South West Forest Services

Application by Highways England (the Applicant) for an Order granting Development Consent for the A417 Missing Link (the Proposed Development)

Scoping consultation and notification of the Applicant's contact details and duty to make available information to the Applicant if requested

Location: A417 Gloucestershire

IN ADDITION TO THE HAZARDS/RISKS NORMALLY ASSOCIATED WITH THE TYPES OF WORK DETAILED ON THIS DRAWING, NOTE THE FOLLOWING SIGNIFICANT RESIDUAL RISKS (REFERENCE SHALL BE MADE TO THE DESIGN HAZARD LOG).

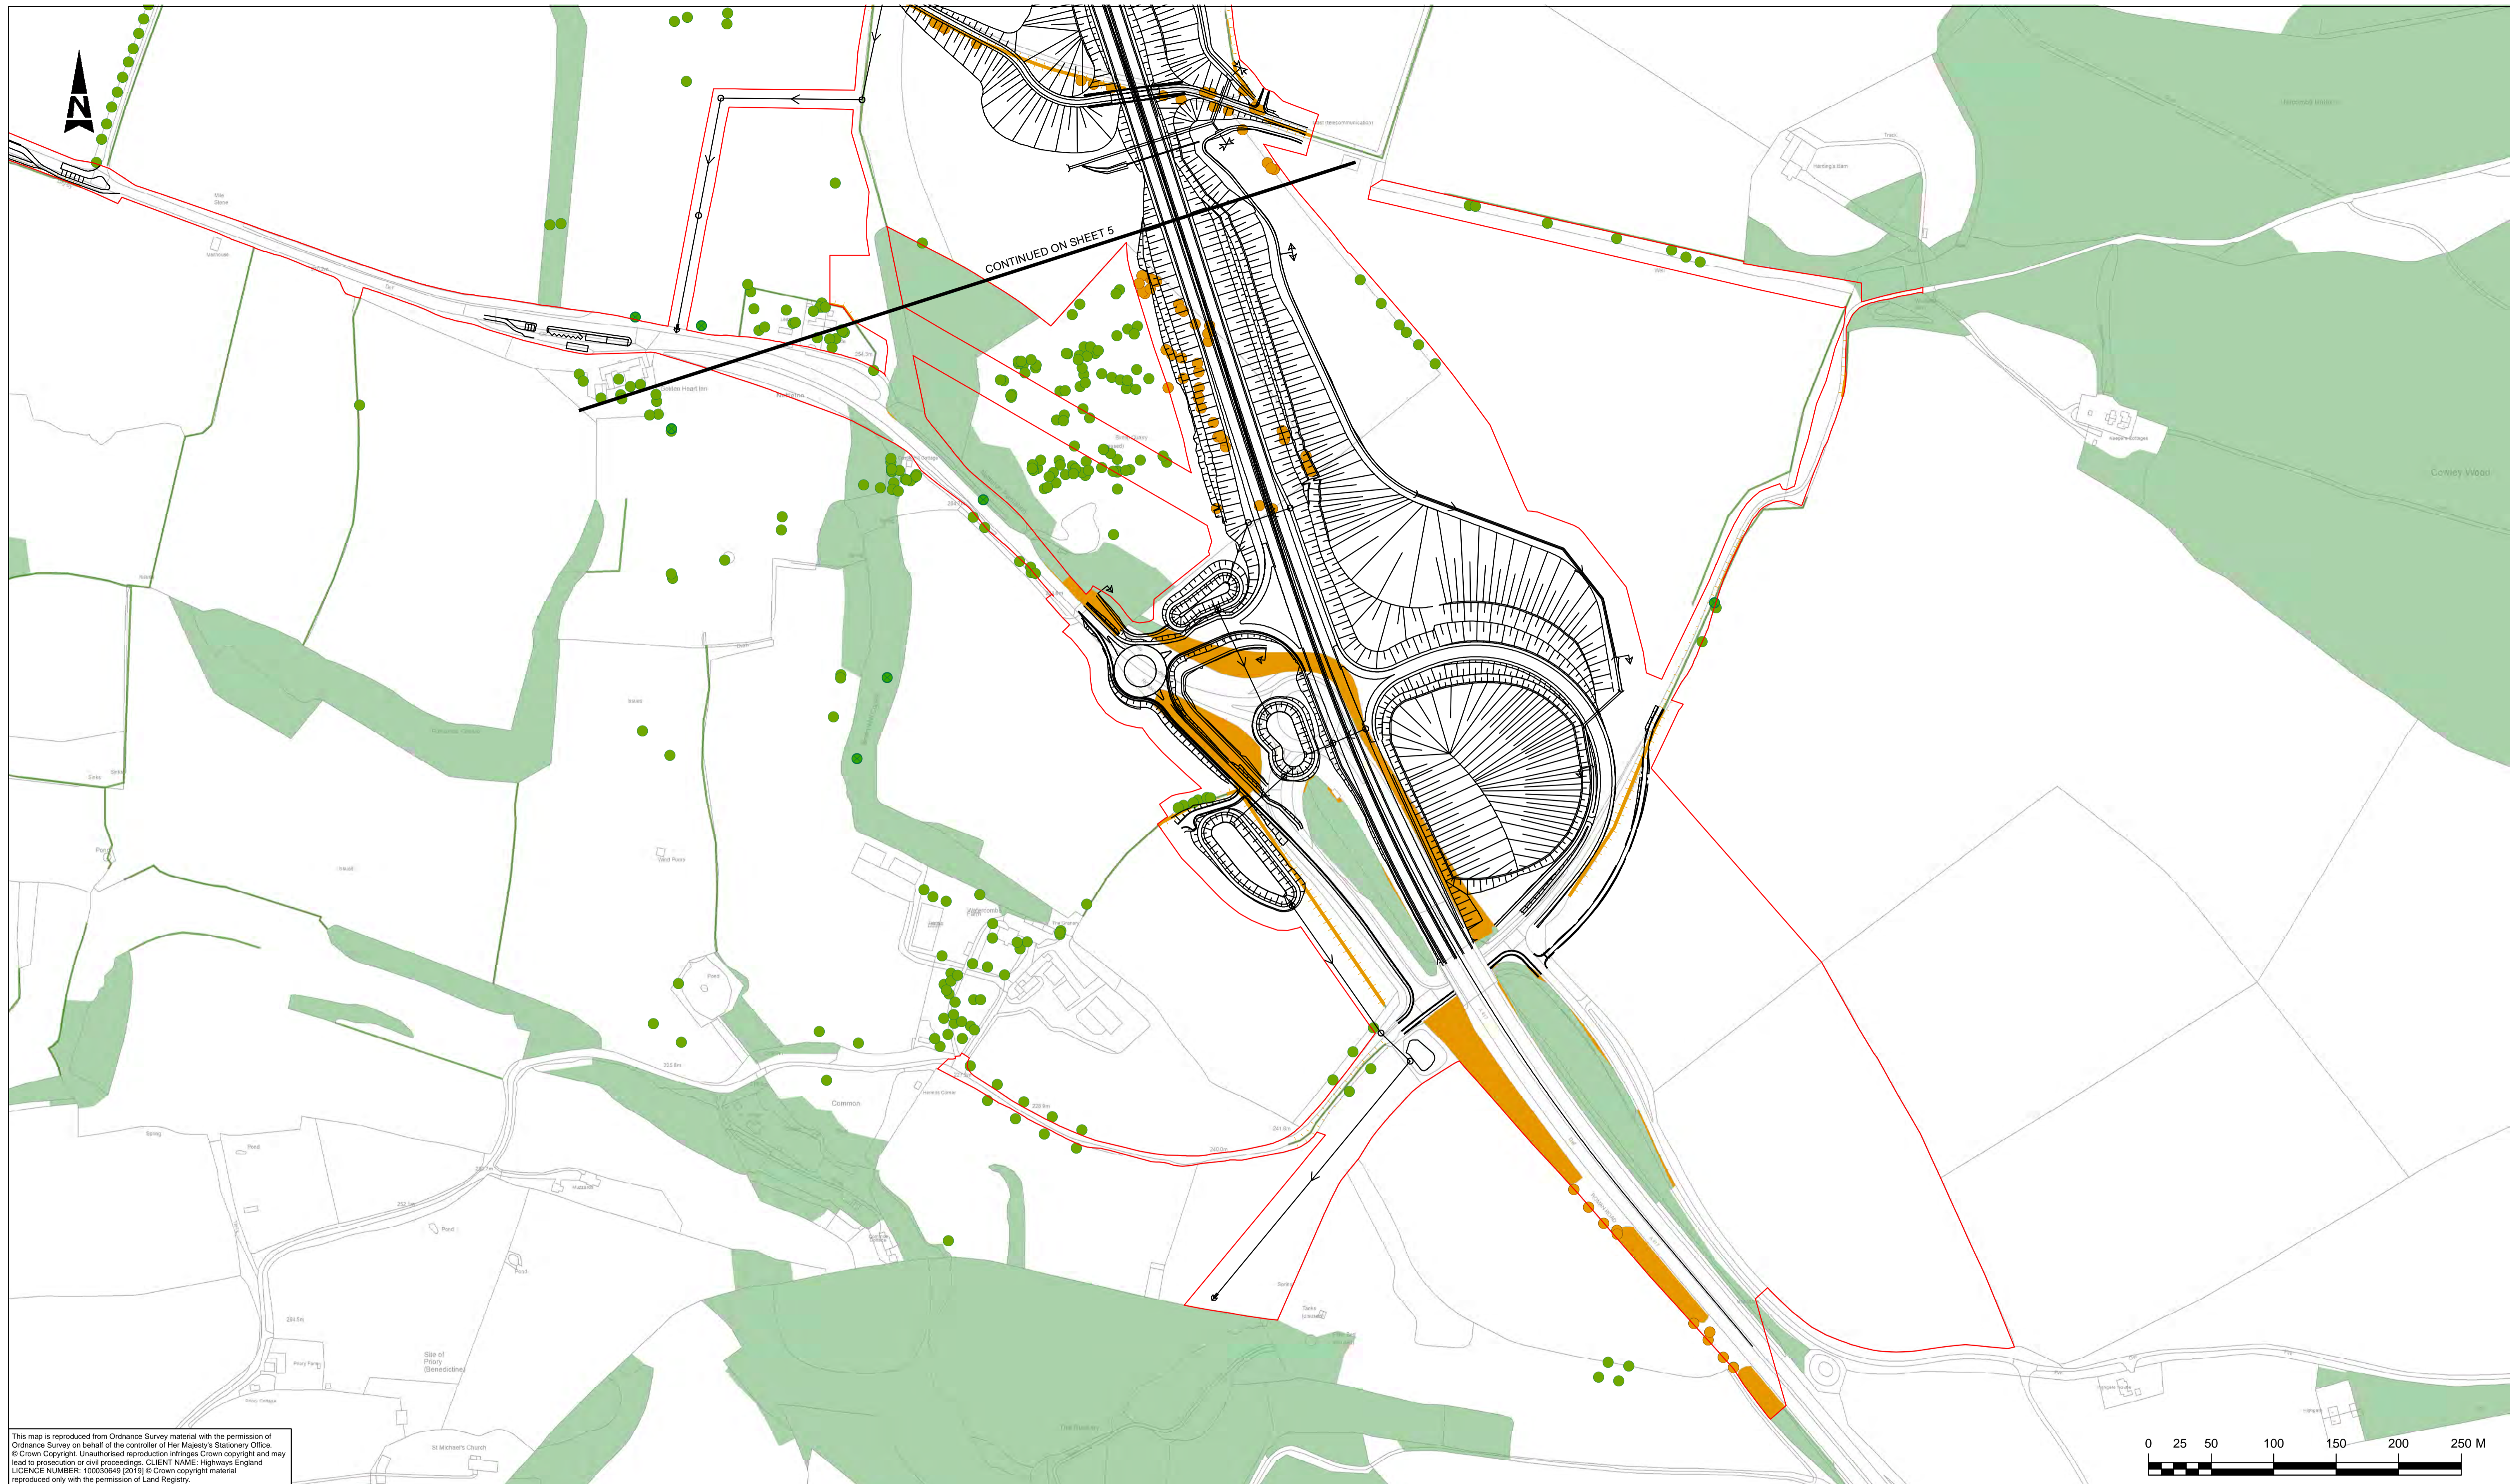
I note that there is a proposal to remove an area of presumed ancient semi-natural woodland which is too small to be on the register but which will be treated as ancient woodland. Our advice would be that no presumed ancient woodland should be removed. It is important that there is no net deforestation so any loss of woodland should be compensated for. Ideally schemes will lead to an increase in woodland cover.

Although there are no large woodlands on the proposed route, there are several existing felling licences and woodland grant agreements in the vicinity of the proposed scheme. It will be important to ensure that the new scheme design does not make it difficult to access and manage any existing woodlands, or to make the recreational use of woodland less enjoyable. Ideally it will enhance opportunities to access, carry out work and extract timber from sustainably managed woodlands.
